<b>Consultation Response from KC, Highways Development Management</b>
<b>2025/92331 Almondbury Working Mens Club, Southfield Road, Almondbury, Huddersfield, HD5 8RY</b>
<b>Variation of conditions 3 (use of floors) and 4 (operating hours) of previous permission 2025/90480 for change of use of from working mens club to mixed use event hall (Sui Generis) incorporating Class E spaces and associated works</b>
<b>Date Responded: 18/09/2025 Responding Officer: D. Stainsby Responding Ref: K6-15SE/29</b>

PHASE	SCALE	SHEET NO.	PROJ.NO.
Section 73 Application	1:200 @ A3	AR-03	C25008

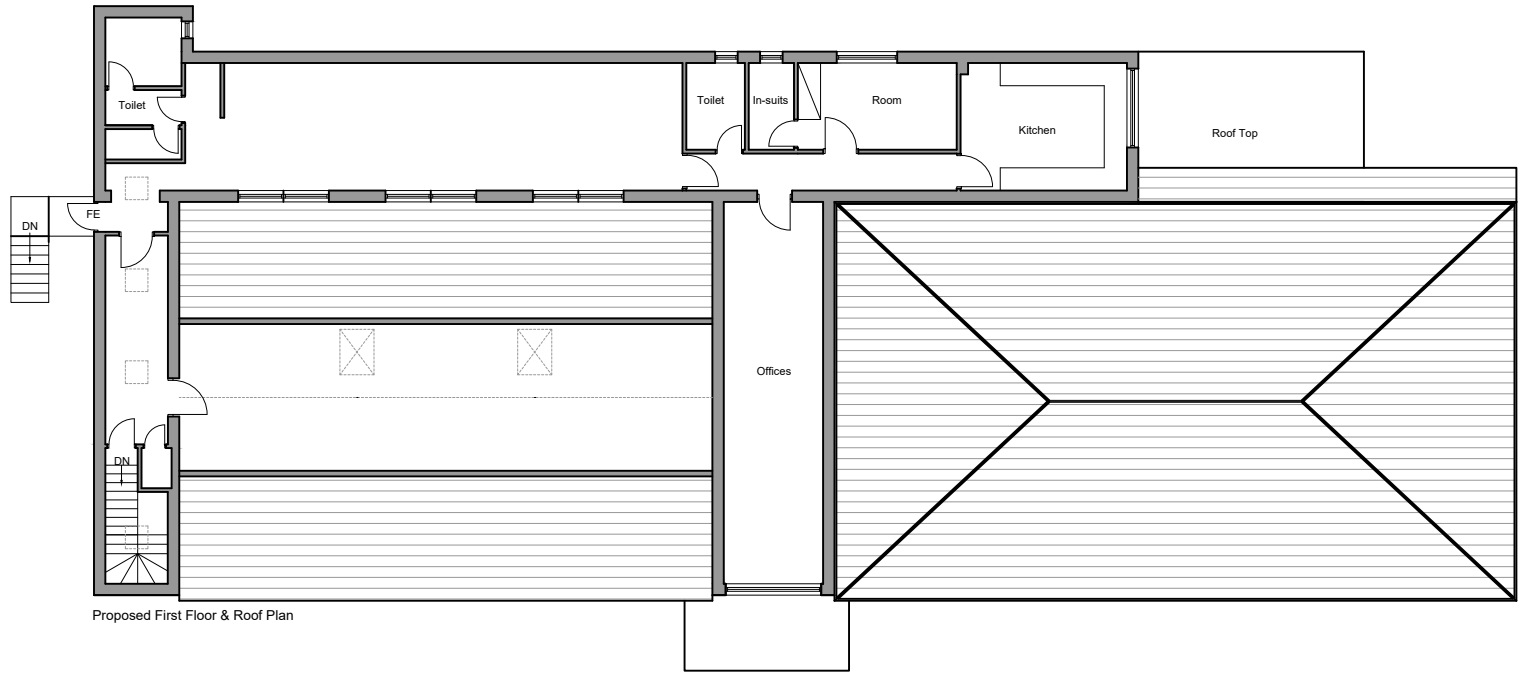
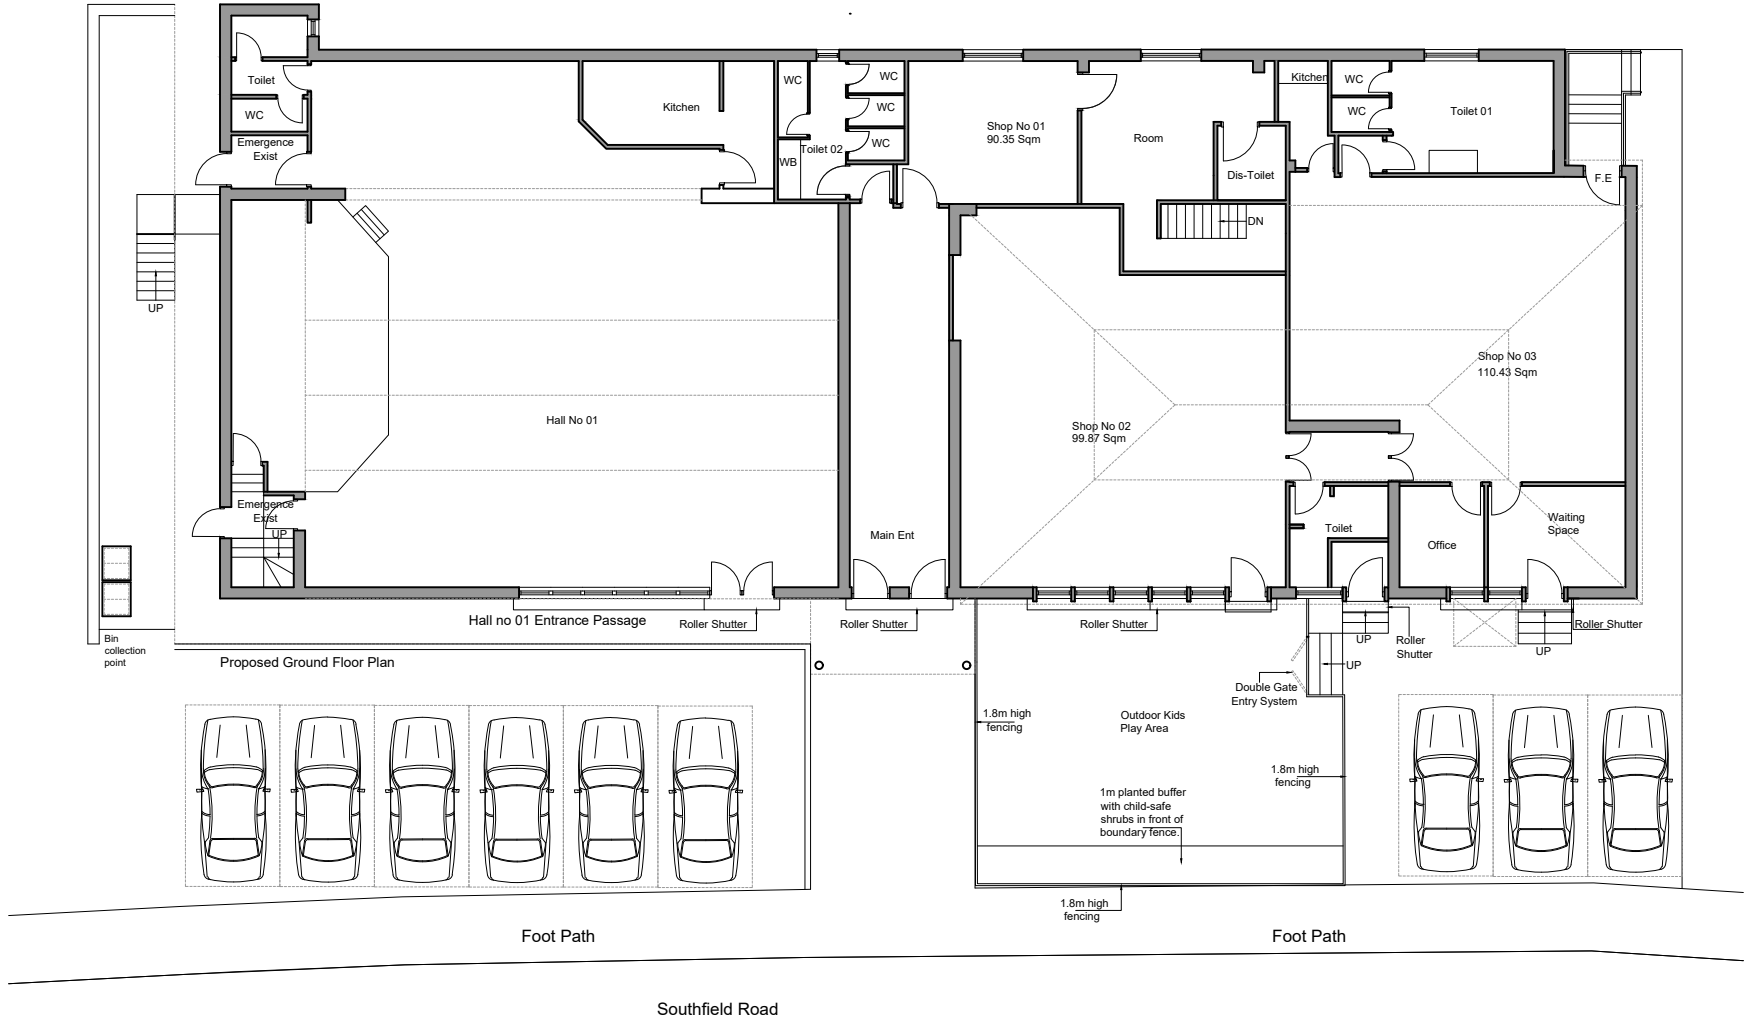
The proposed variation will remove 4 car parking spaces reducing the total number from 13 to 9

Although no information has been provided on the number of children or staff required for the nursery it is expected that 9 car parking spaces will still be adequate.

If the nursery does not go ahead or closes in the future and the units remain or return to being two separate units a condition should be imposed that the 4 car parking places be reinstated.
